CITY OF PORTLAND, MAINE

October 29th, 2015

Project Name: Subdivision and Change of Use/Renovation of existing building to create Ten Residential Units
Project #: #2015-162; Level III Subdivision and Site Plan
Address: 415 Cumberland Avenue, Portland
CBL: 036 G033 001
Applicant: Patrick Ducas
Planner: Jean Fraser

Drawing file: Oct 22 for hearing / Plan P2 Draft Subdivision Plat - Revised Civil Site Plan 10-22-15.pdf

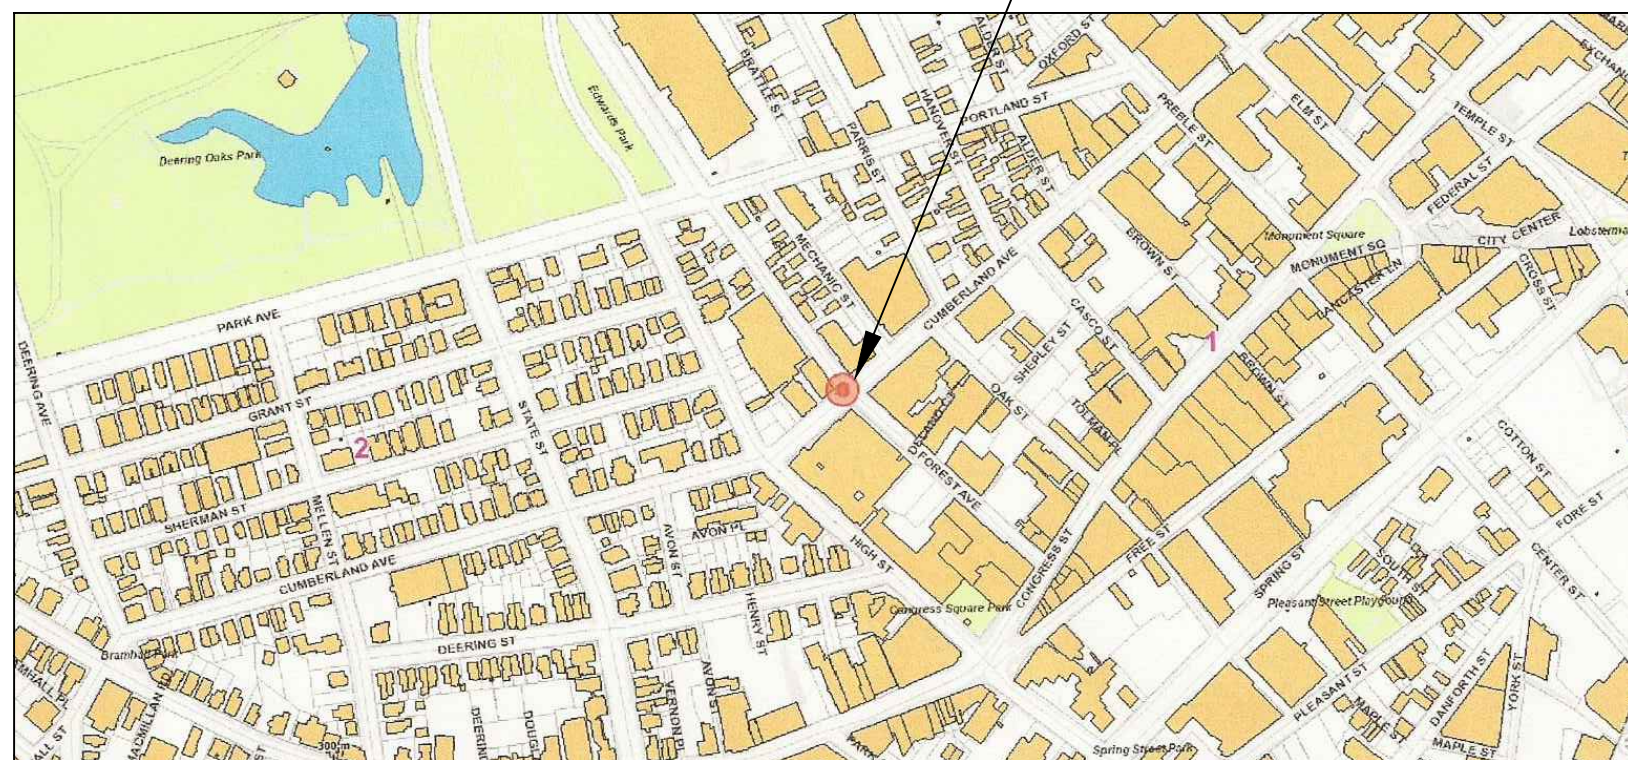
- i. That the applicant shall submit a revised site plan/plat that shows the location and design of the 4 bicycle parking spaces, the proposed planting in the front garden area including 2 street trees on the site, and the replacement ADA ramp panel in the ROW at the corner of Forest Avenue and Cumberland Avenue (to meet the City's Technical Standards for any work in the ROW), for review and approval by the Planning Authority prior to the issuance of a building permit; and

All requirements have been met. The subdivision plat (Plan P2.) has been reviewed by the Department of Public Services (DPS) Surveyor, the Legal Department and the Fire Department staff (Attachments 1, 4 and 5). The Legal Department and DPS Surveyor have requested clarification regarding the easements and other survey information; the draft plat in Plan P2 will need to be revised to address these comments.

5 Top Roof drainage plan
1/4" = 1'-0"

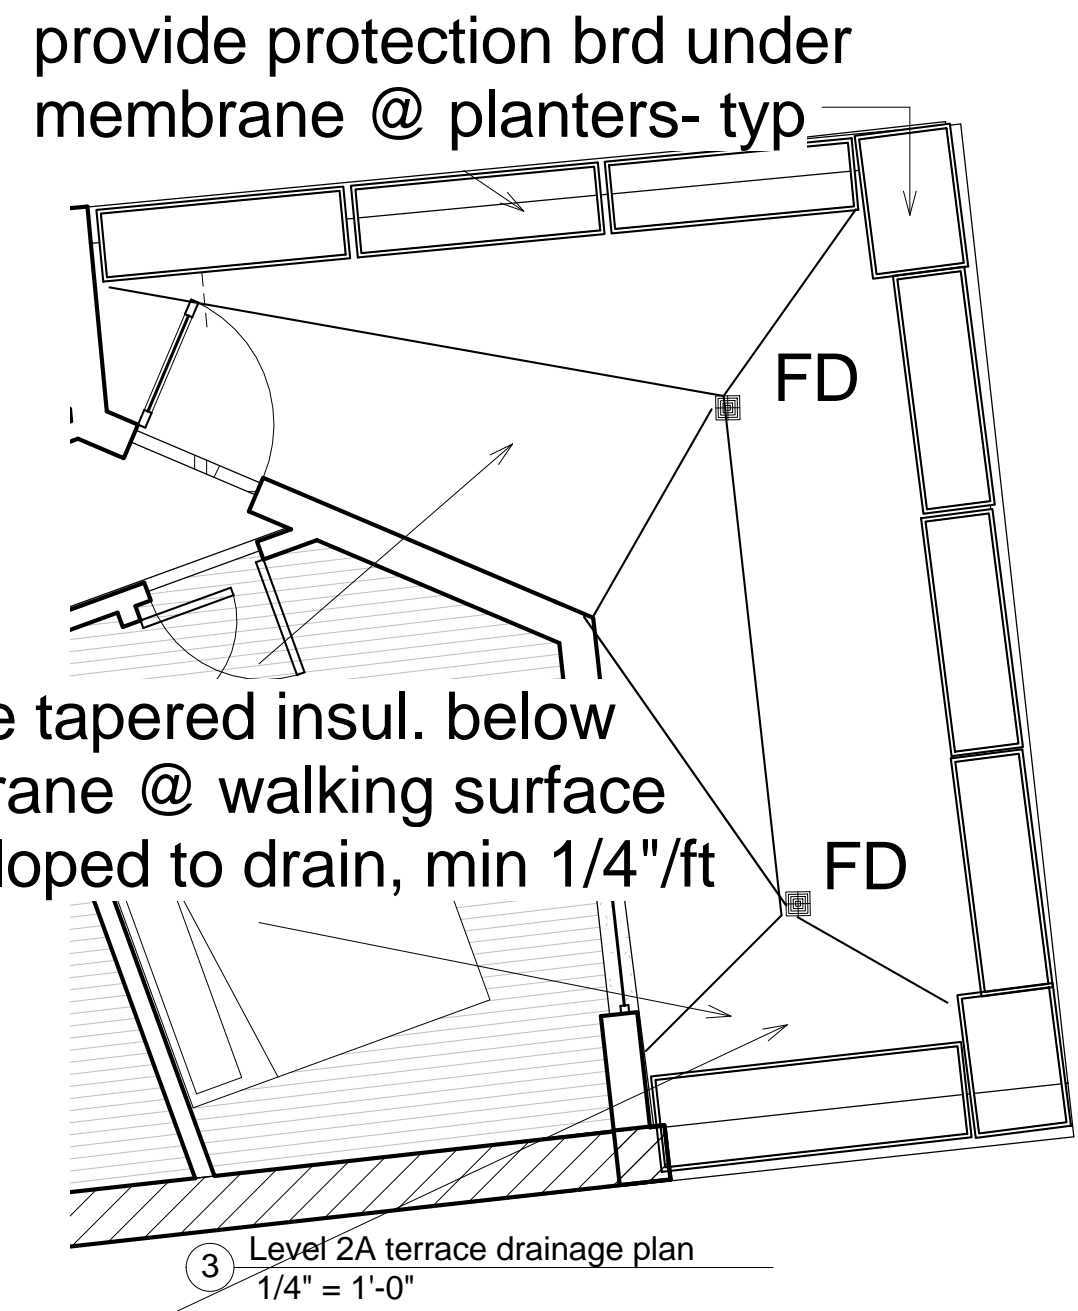
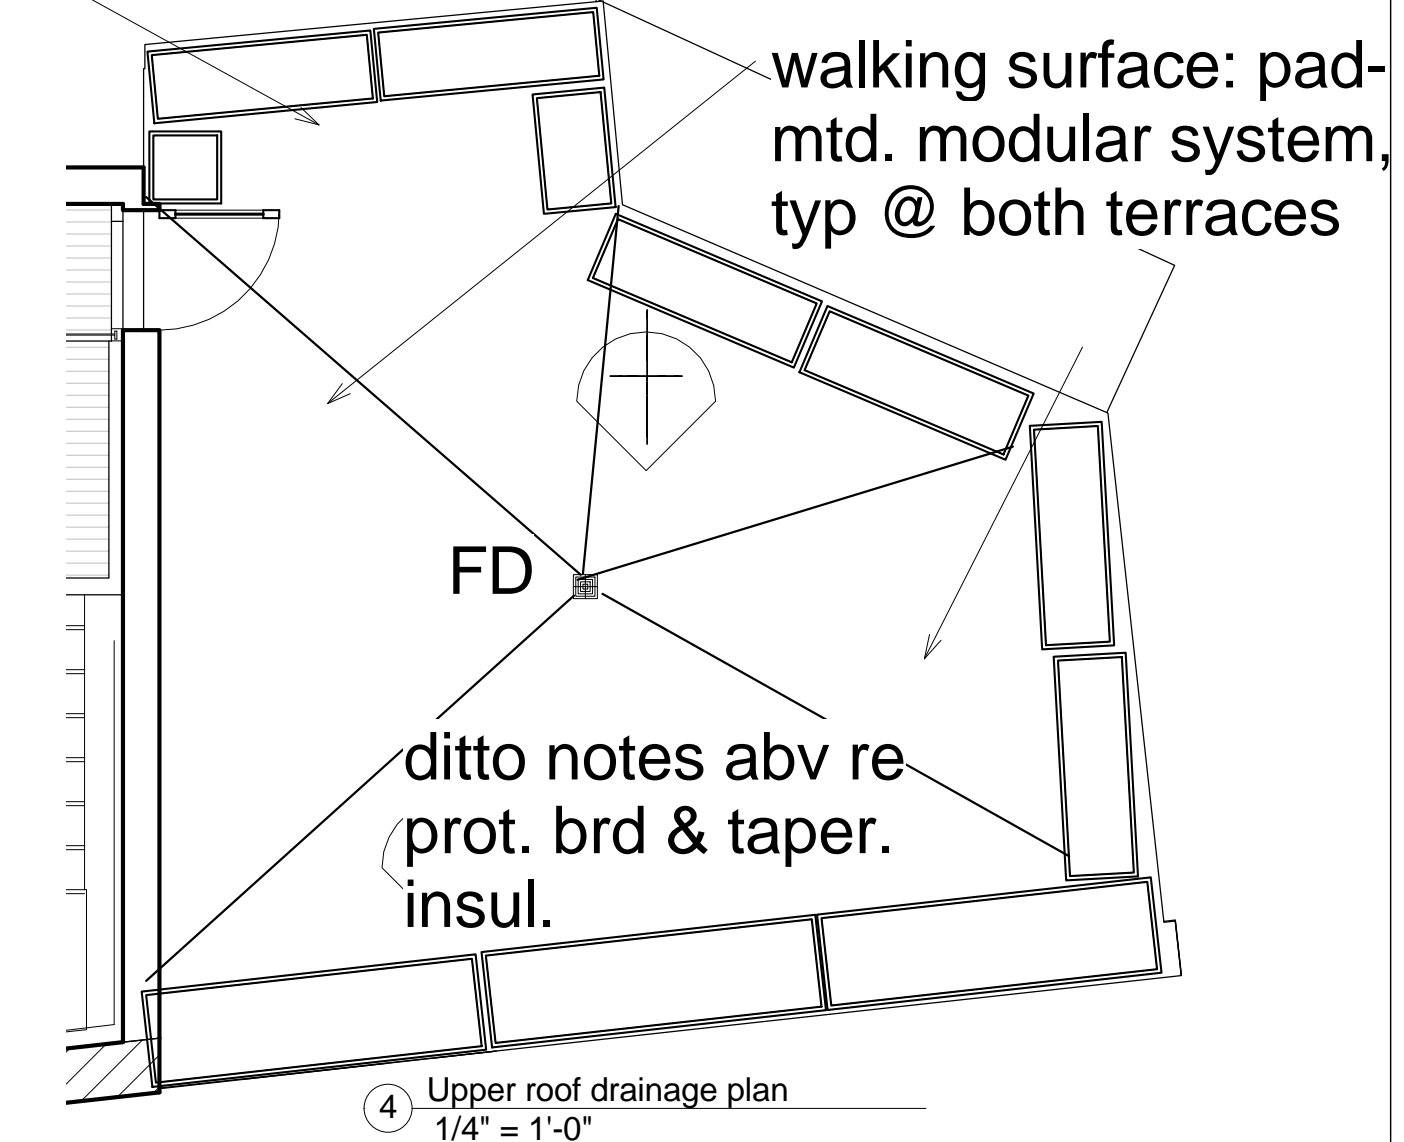
- ii. That the applicant shall submit plans showing the proposals for: A) Any modifications to the roof drainage to meet the Wastewater Capacity Letter conditions (that all roof drainage be directed to the sidewalk or street level); and B) All upgrades to the existing water and sewer utilities at the existing locations, including restoration of the sidewalk (to meet the City's Technical Standards for any work in the ROW); both for review and approval prior to the issuance of a building permit; and

The reuse of the building does not require any upgrading to meet current stormwater requirements, but the DPS in their Wastewater Capacity letter ([Attachment 1](#)) has requested that all rainwater downpipes be directed to the sidewalk or street level and not be connected to the sewer. The applicant is checking on whether a central roof drain is connected to the sewer and the suggested condition requires that if there is a connection that the proposals to redirect that drainage be submitted for review and approval.
